Rezoning Transportation Analysis

Petition Number: 2024-029

Date	Description
4-24-24	First Review (IW)

TECHNICAL DATA SHEET

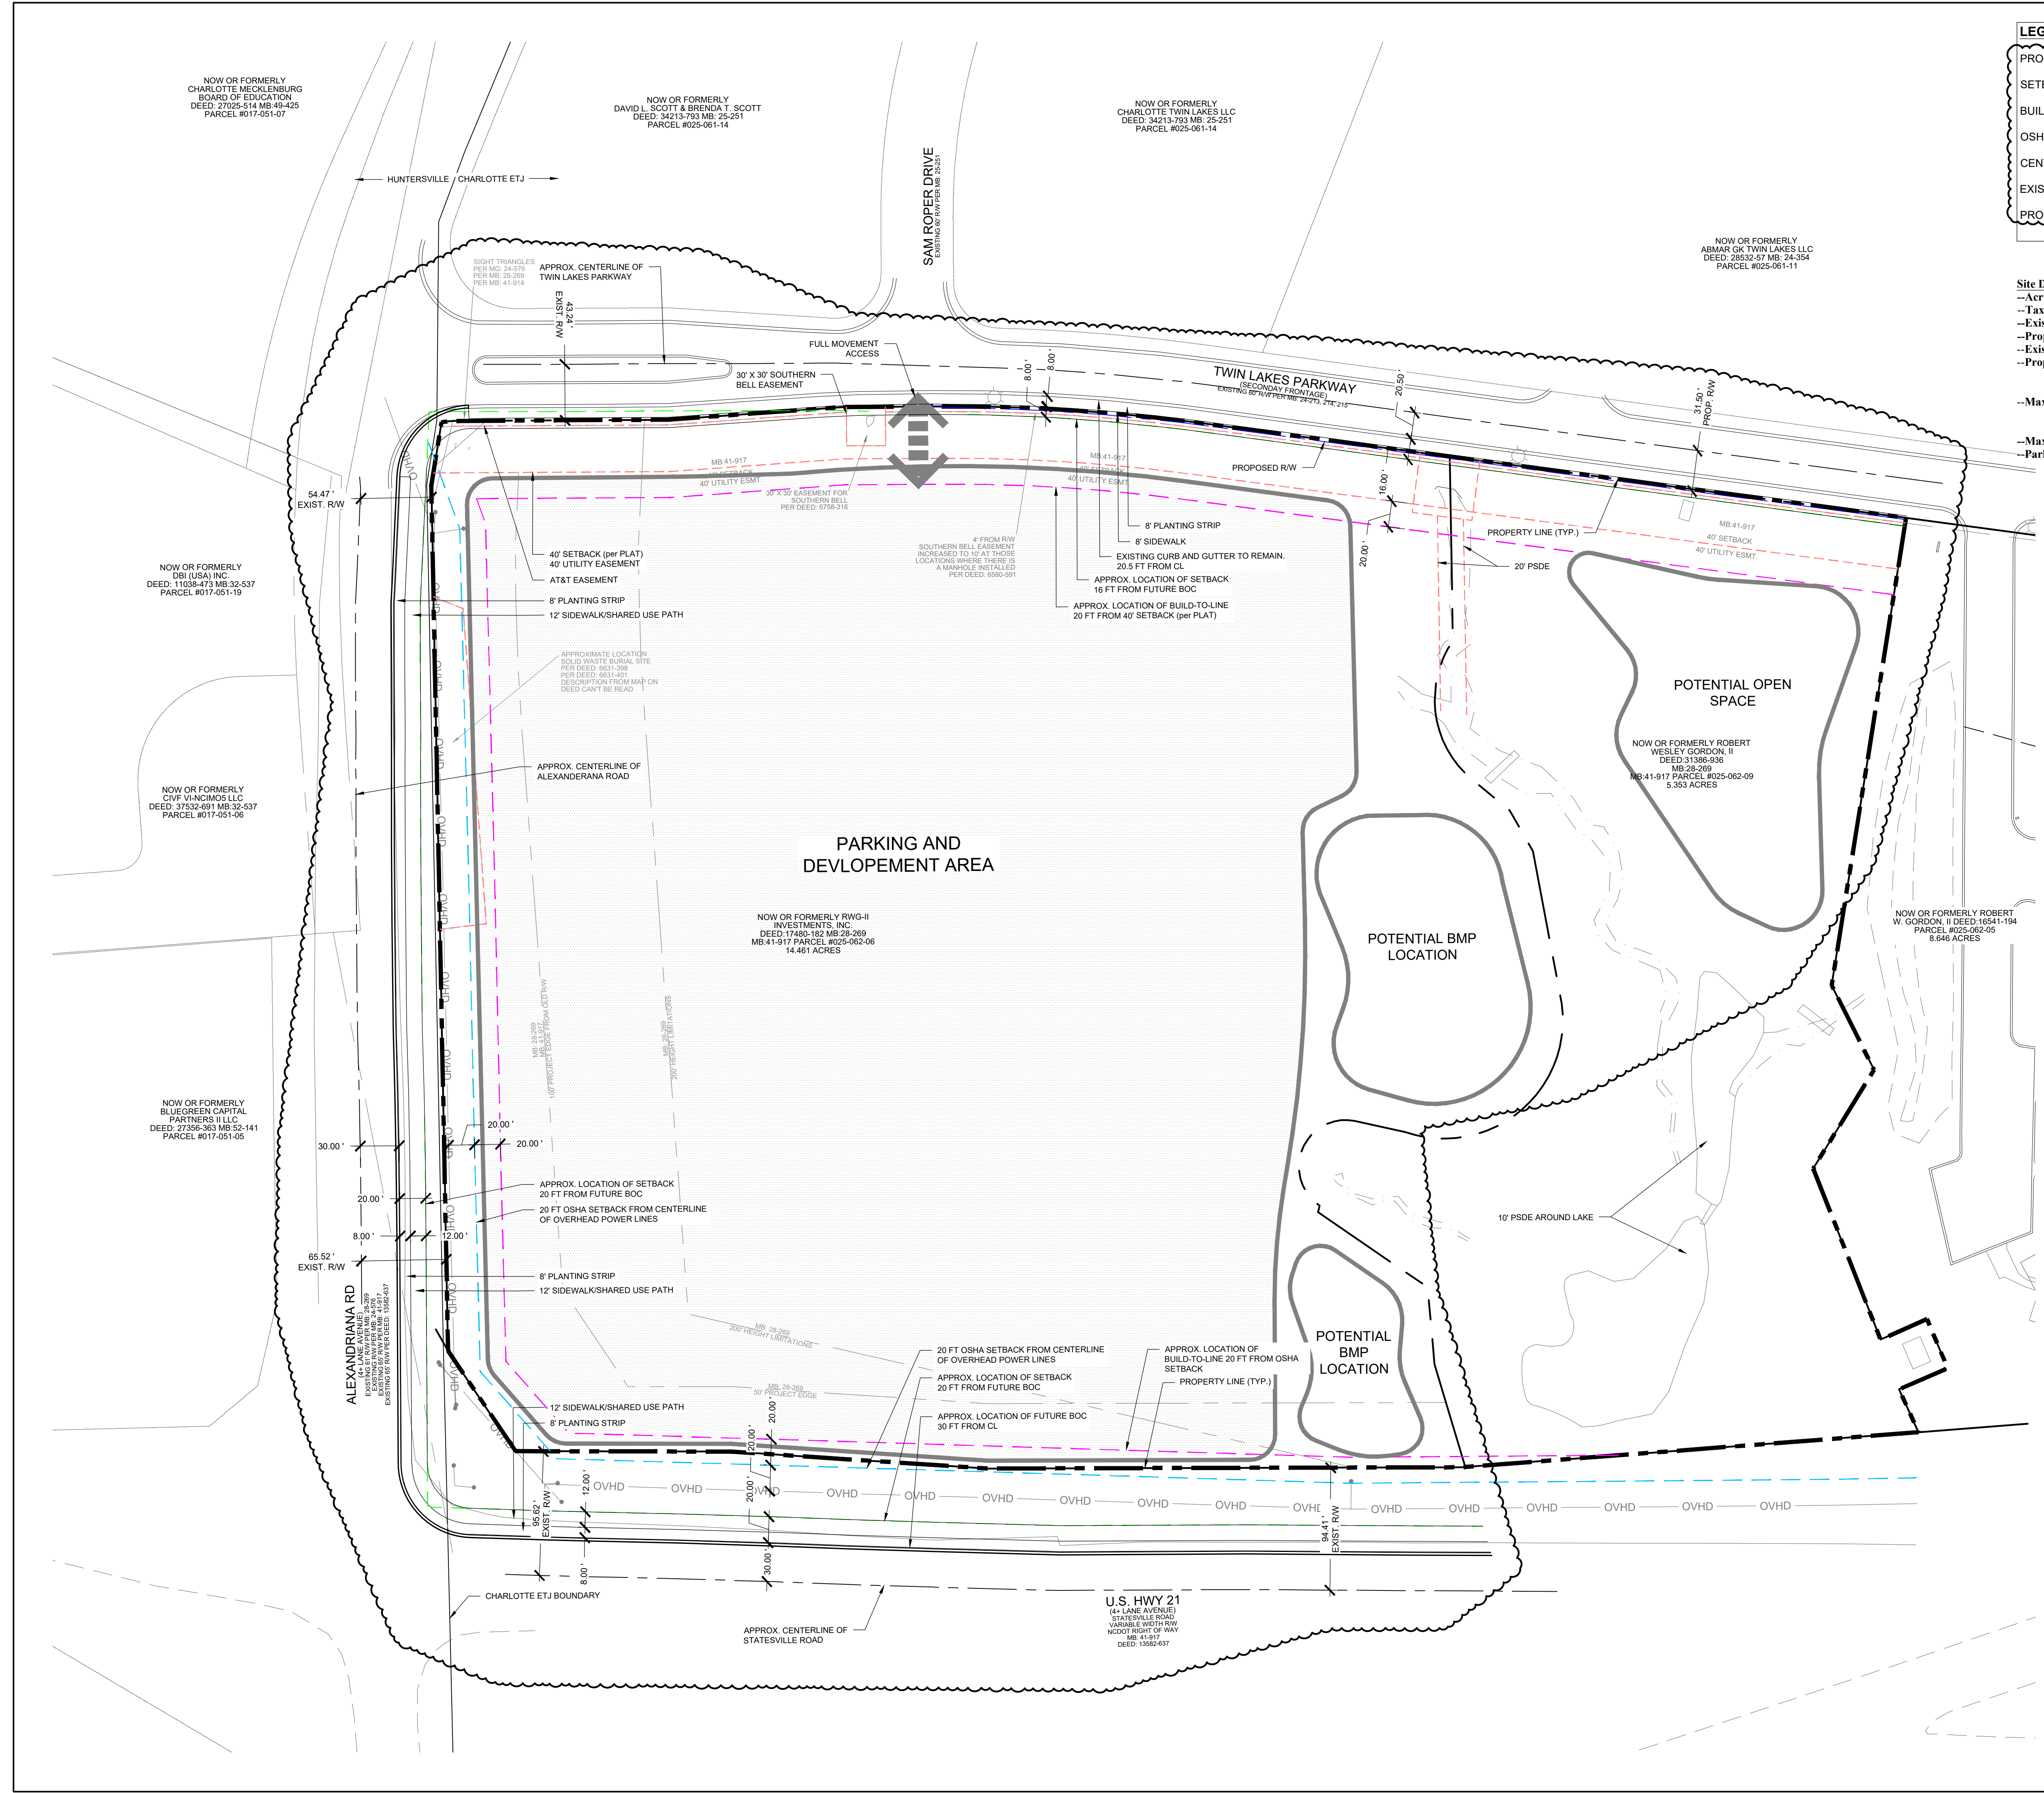
- a. **Alexandriana Road:** Location of future back of curb and gutter to be constructed 30' from centerline.

- b. **Statesville Road:** Location of future back of curb and gutter to be constructed 30' from centerline.

- c. **Twin Lakes Pkwy:** Location of future back of curb and gutter to be 17.5' from centerline..

Label and dimension the curb and gutter from the centerline for each road on the site plan.

- 3. Revise site plan and conditional note(s) to commit to dedicate 50' of right-of-way from the Alexandriana road centerline. The site plan shall label and dimension the right-of-way from the road centerline.

4. Revise site plan and conditional note(s) to commit to dedicate 50' of right-of-way from the Statesville road centerline. The site plan shall label and dimension the right-of-way from the road centerline

5. Revise site plan and conditional note(s) to commit to dedicate 31.5' of right-of-way from the Twin Lakes Pkwy road centerline. The site plan shall label and dimension the right-of-way from the road centerline

6. Revise site plan and conditional note(s) to commit to construct bicycle facilities on Alexadriana Road by installing a 12' multi-use path behind the 8' Planting Strip in accordance with the council-adopted Charlotte Streets Map. Multi-use paths maintained by the City shall meet ADA/PROWAG requirements.

7. Revise site plan and conditional note(s) to commit to construct bicycle facilities on Statesville Road by installing a 12' multi-use path behind the 8' Planting Strip in accordance with the council-adopted Charlotte Streets Map. Multi-use paths maintained by the City shall meet ADA/PROWAG requirements.

9. NCDOT REQUIREMENT: Revise site plan and conditional note(s) to commit to removing access from Alexanderana road. NCDOT is only allowing access for this site to come off of Twin Lakes Pkwy.
